CITY OF ALBUQUERQUE

October 19, 2021

Re: Los Altos Park Renovation – Phase I, K20D037

Based upon the information provided in your submittal received 09/01/2021, the Grading & Drainage Plans are not approved for Building Permit and Grading Permit. The following comments need to be addressed for approval of the above referenced project:

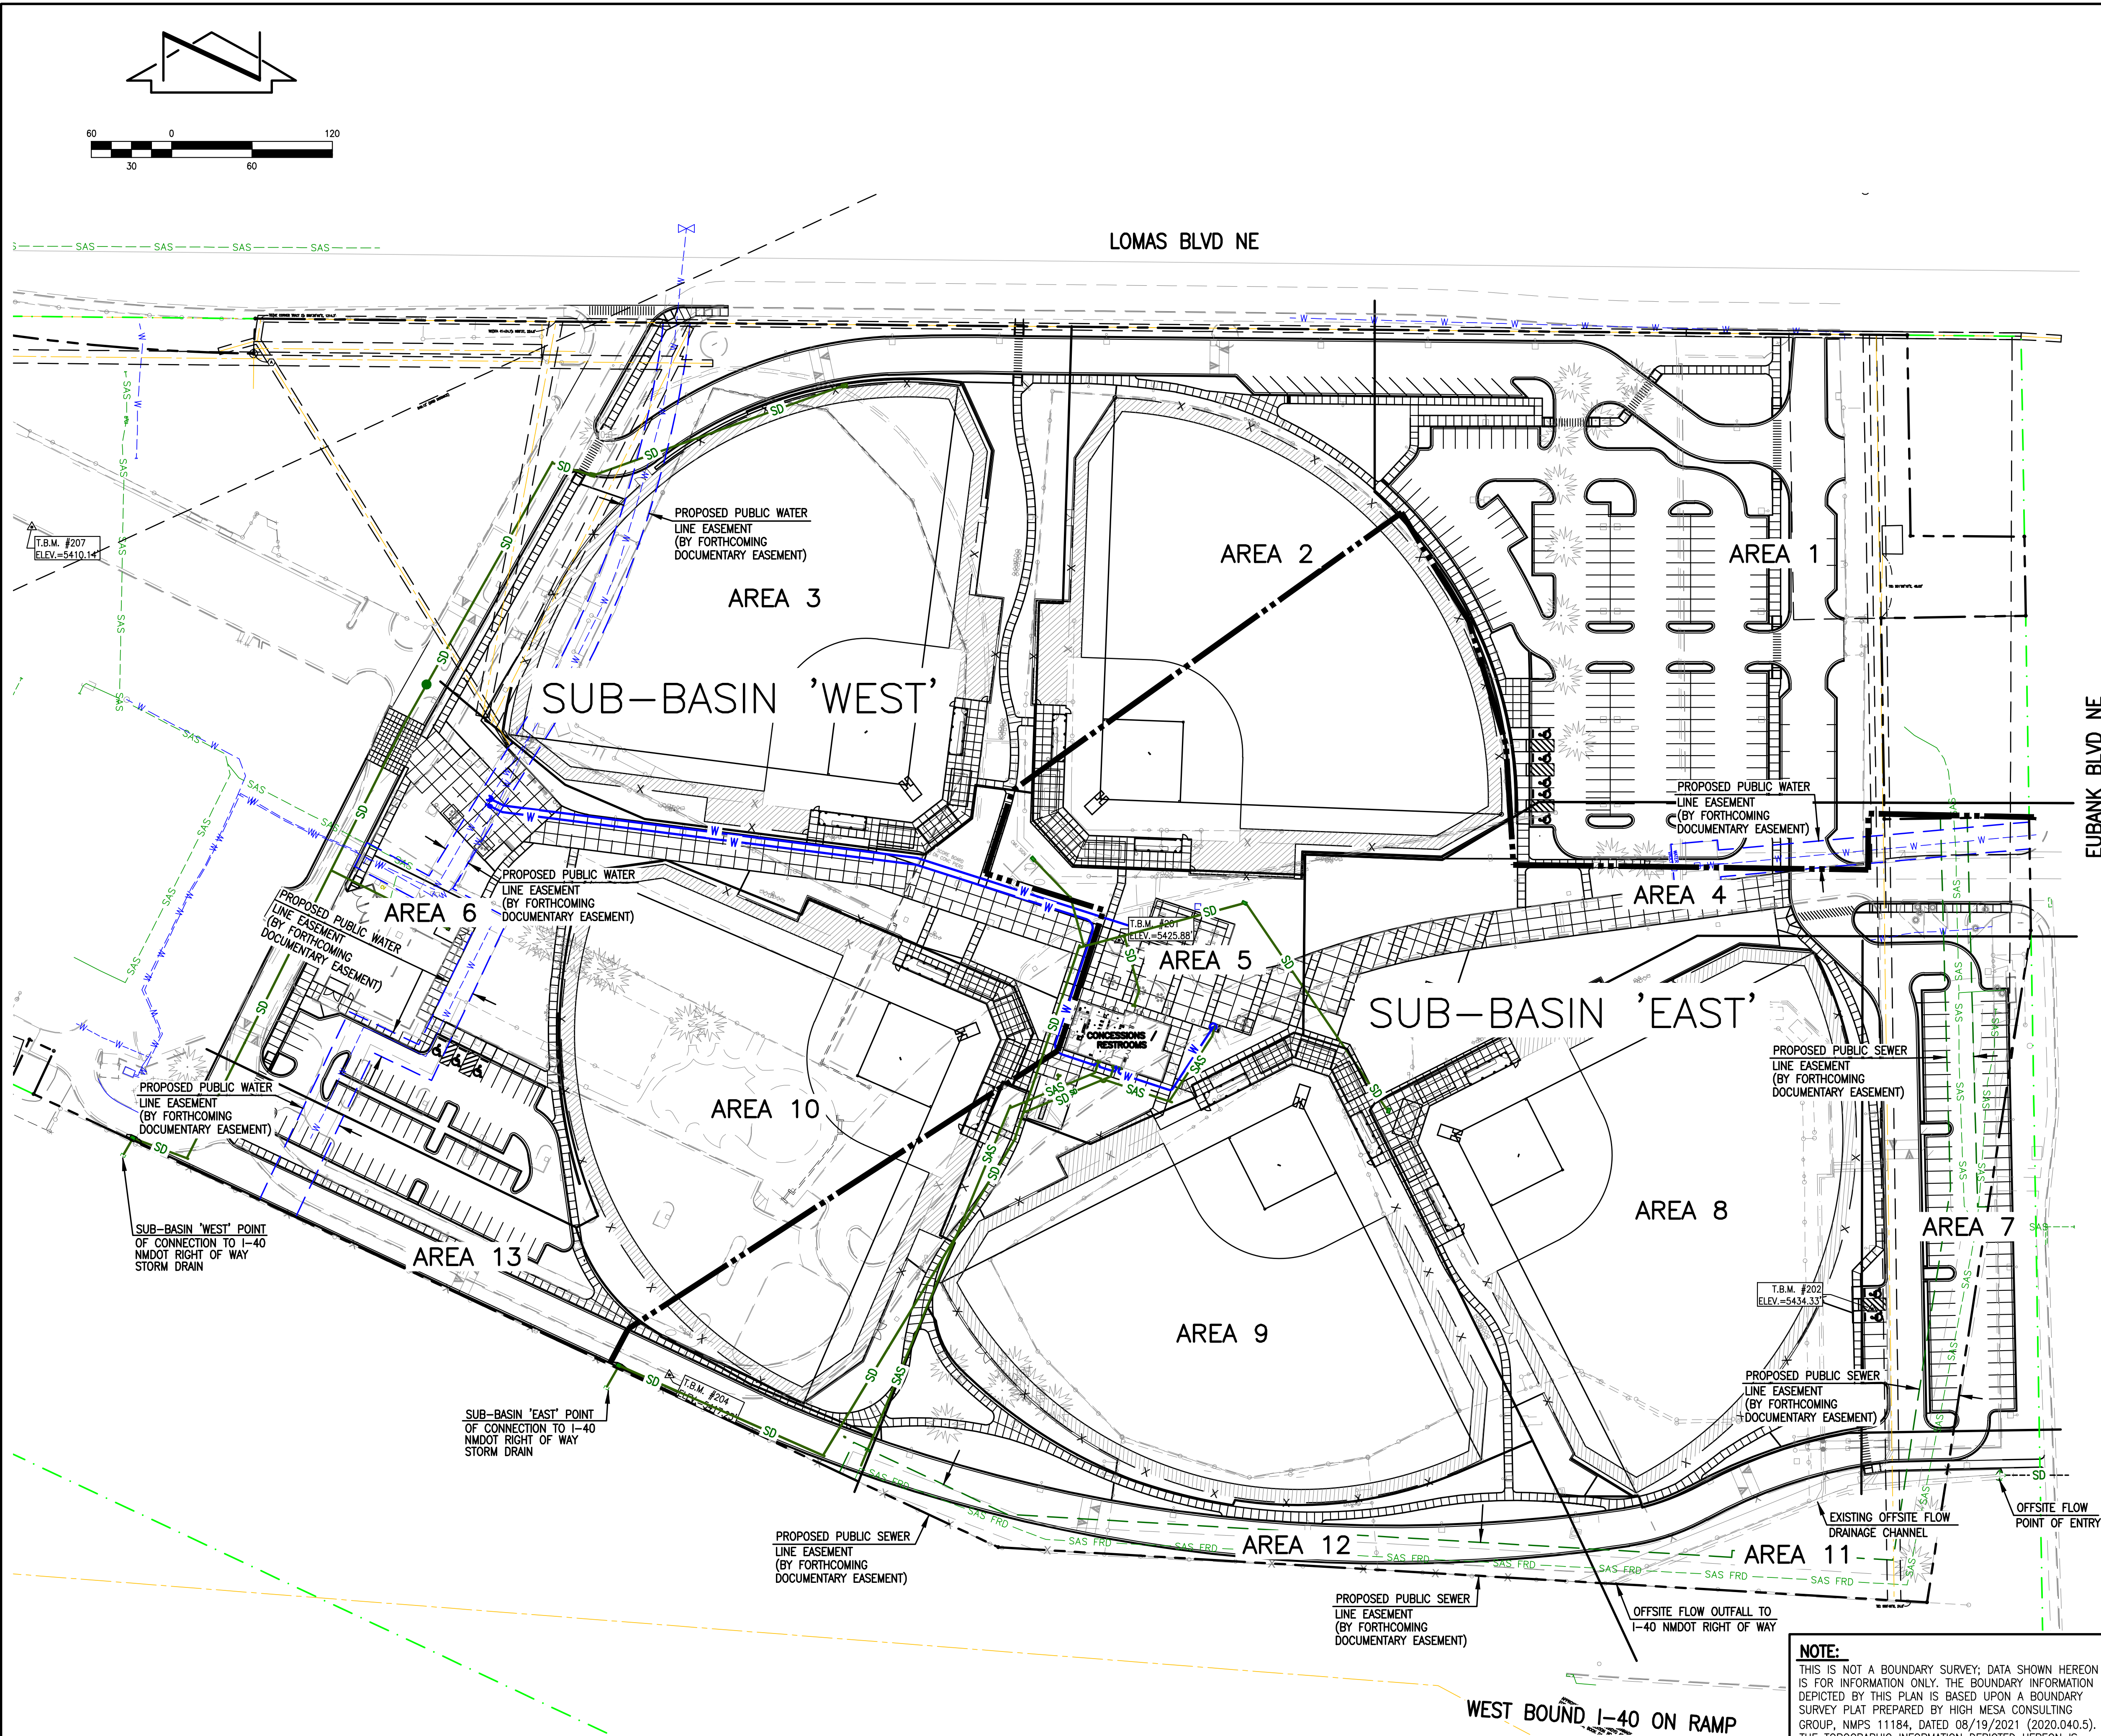
1. Provide an overall grading and drainage plan.
2. Clearly label 1st flush volume ponds including the volume for each ponding area. There appears more landscaping areas where can be used for 1st flush volume. See attached markup plans in red.
3. Provide calculations for inlets and storm drain pipes. A separate overall storm drain system plan would be helpful.
4. Under the drainage notes there is reference to a 48" RCP extending across Eubank. On Sheet CG111 calls out a 54" RCP.
5. Sheet CG501 was referenced for sidewalk culvert detail. Please provide details.
6. Provide details for the connections into NMDOT inlets. NMDOT approval and permitting will be required for the work within NMDOT's right-of-way.
